Deadline 10 Submission
Final Written Representation
On behalf of Marlesford Parish Council
Regarding NNB Generation Company (SZC) Limited DCO Application

Richard Cooper
Councillor
Marlesford Parish Council

4th October 2021

Marlesford PC Final Written Representation

**DRAWING TITLE:**  
 SOUTHERN PARK AND RIDE  
 PROPOSED LIGHTING AND CCTV PLAN  
 KEY PLAN

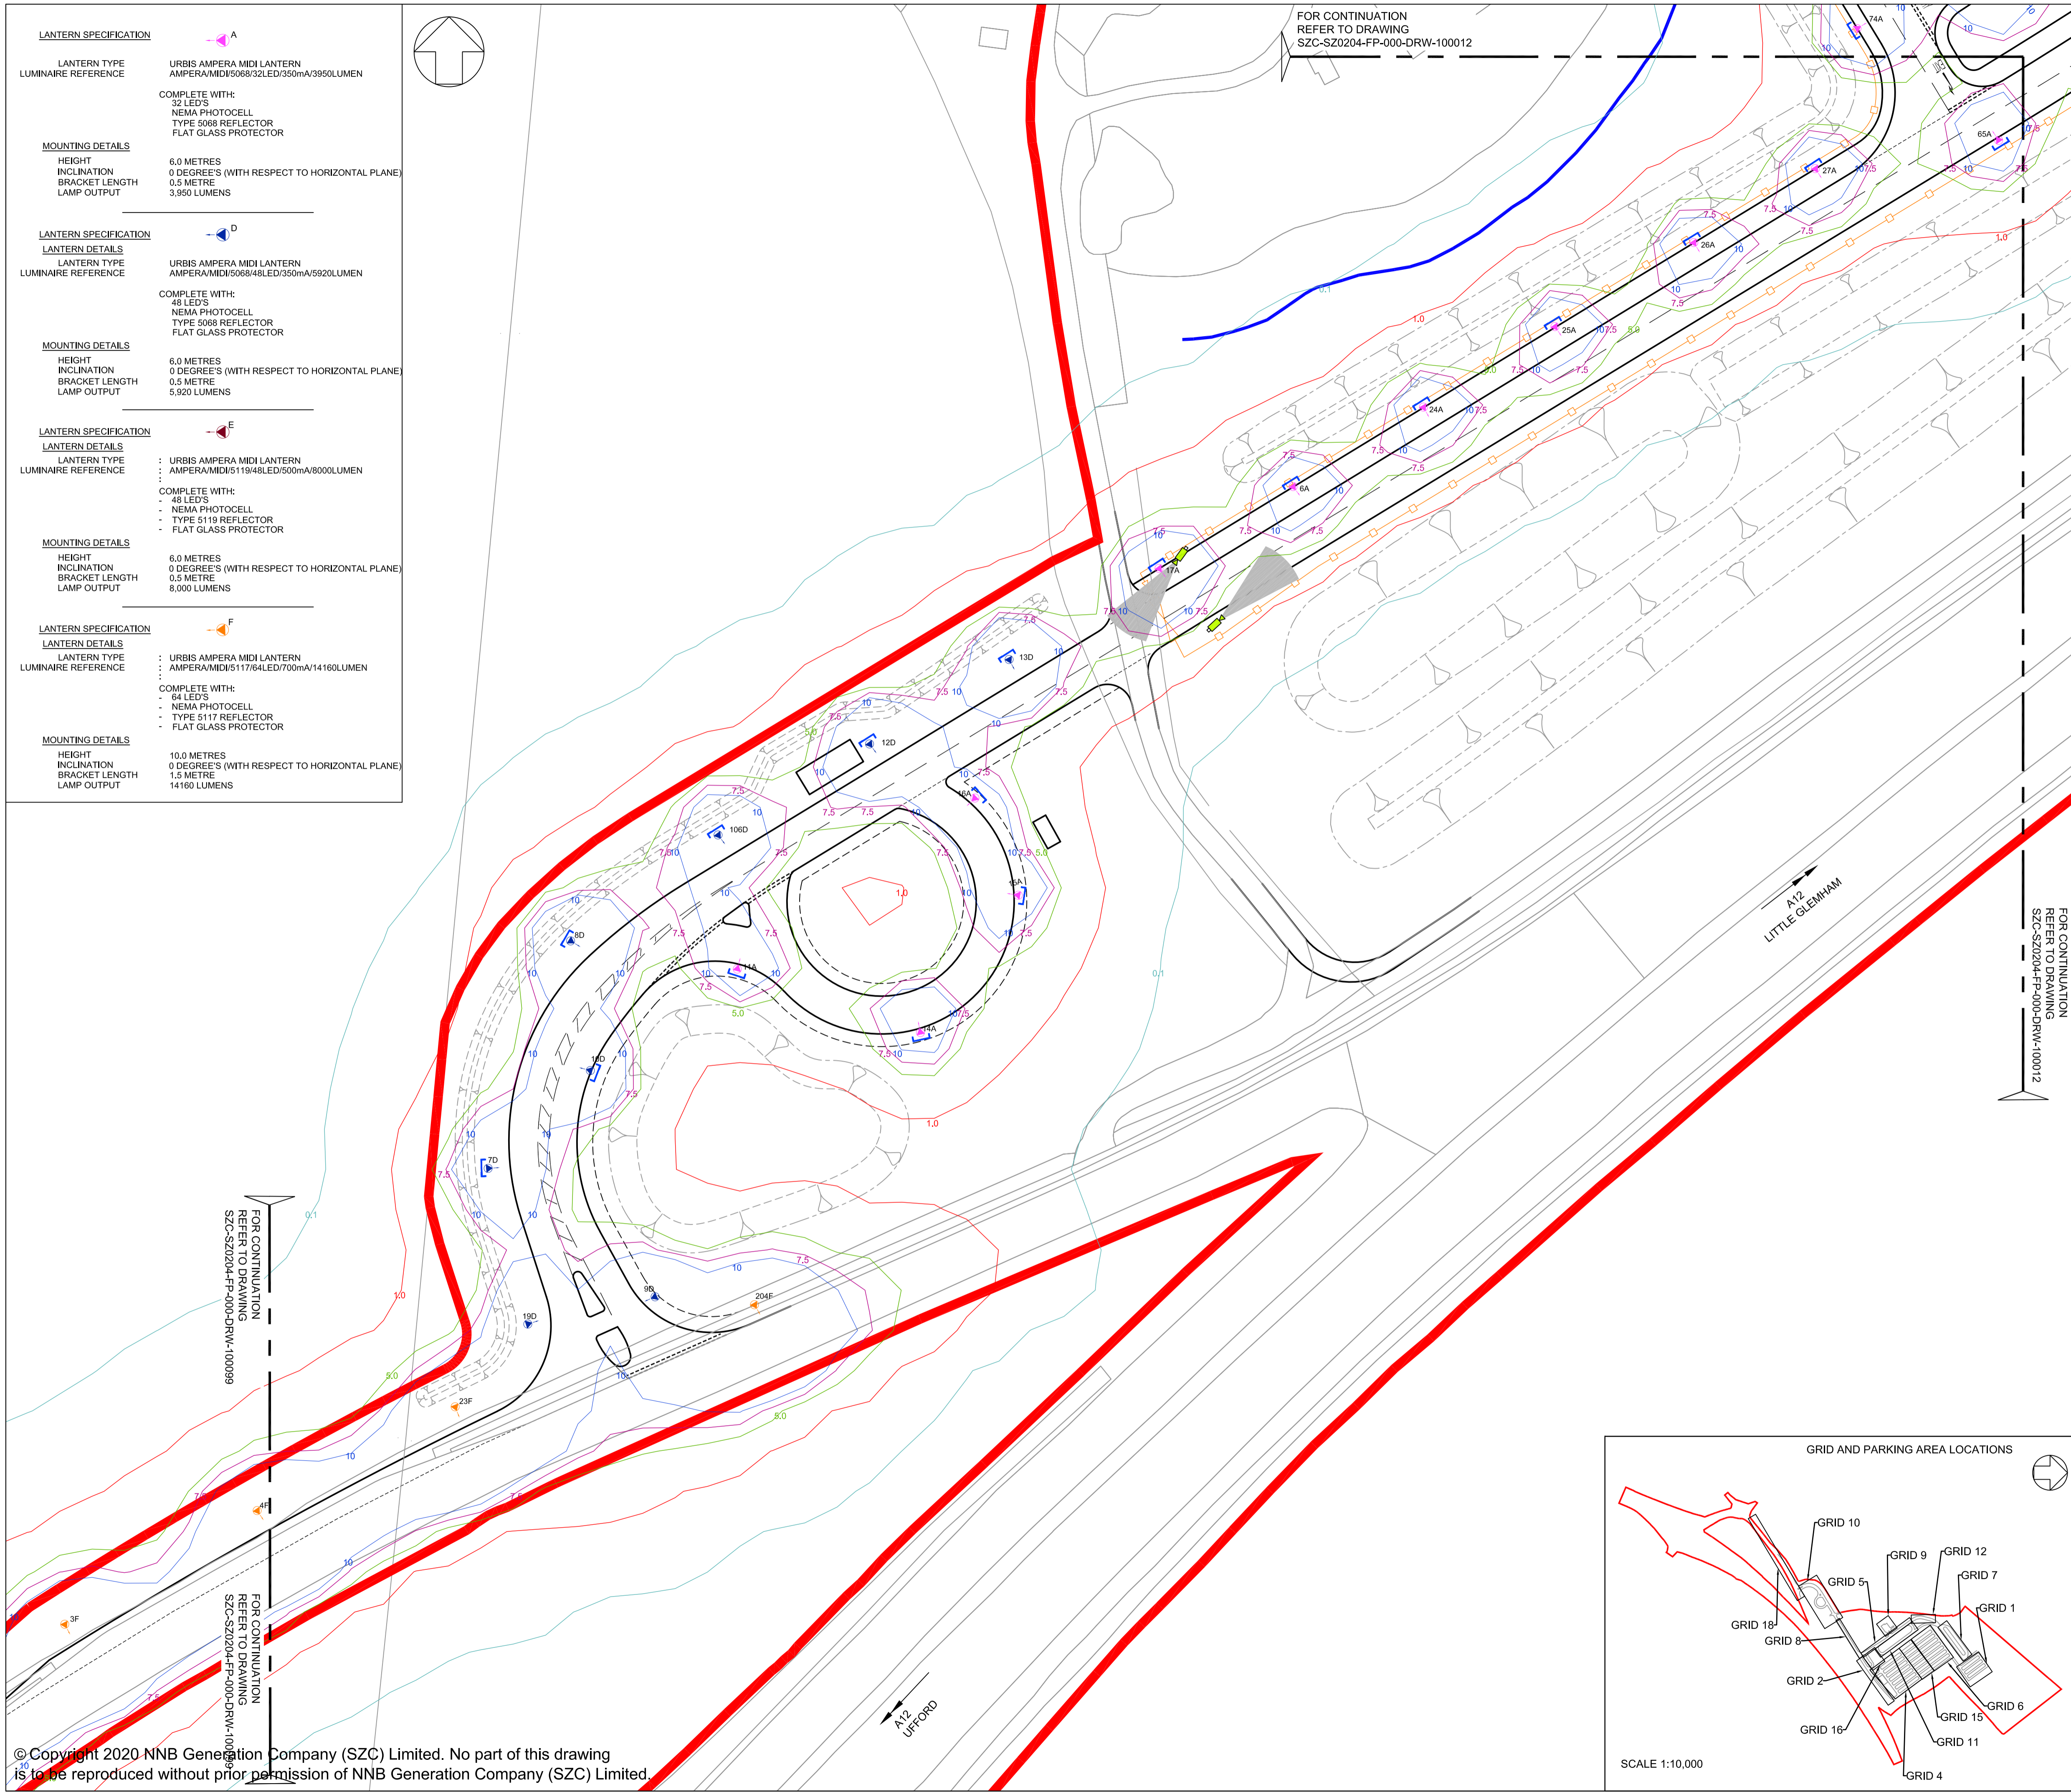
<ul style="list-style-type: none"> • We continue to maintain that two visual receptors have been omitted from the SP&R LVIA (see [REP5-237]). These are Marlesford Hall (OS map ref 323 586) and Public Footpath Marlesford (OS map ref 321 585). We believe these viewpoints should have been included and would ask the ExA to require the Applicant to carry out the appropriate work to include them. • We still argue (as we did at [REP7-209]) that two noise receptors that will be affected by the SP&R have been omitted. They are Ford Gatehouse (IP13 0AS) and Marlesford Hall (IP13 0AU). • We have already voiced our concerns regarding lighting of the SP&R (Deadline 5 [REP5-237]) and we expect the Applicant to work with us to ensure that light spill and diffusion into the night sky are minimised so as to cause least impact to our relatively dark skies.
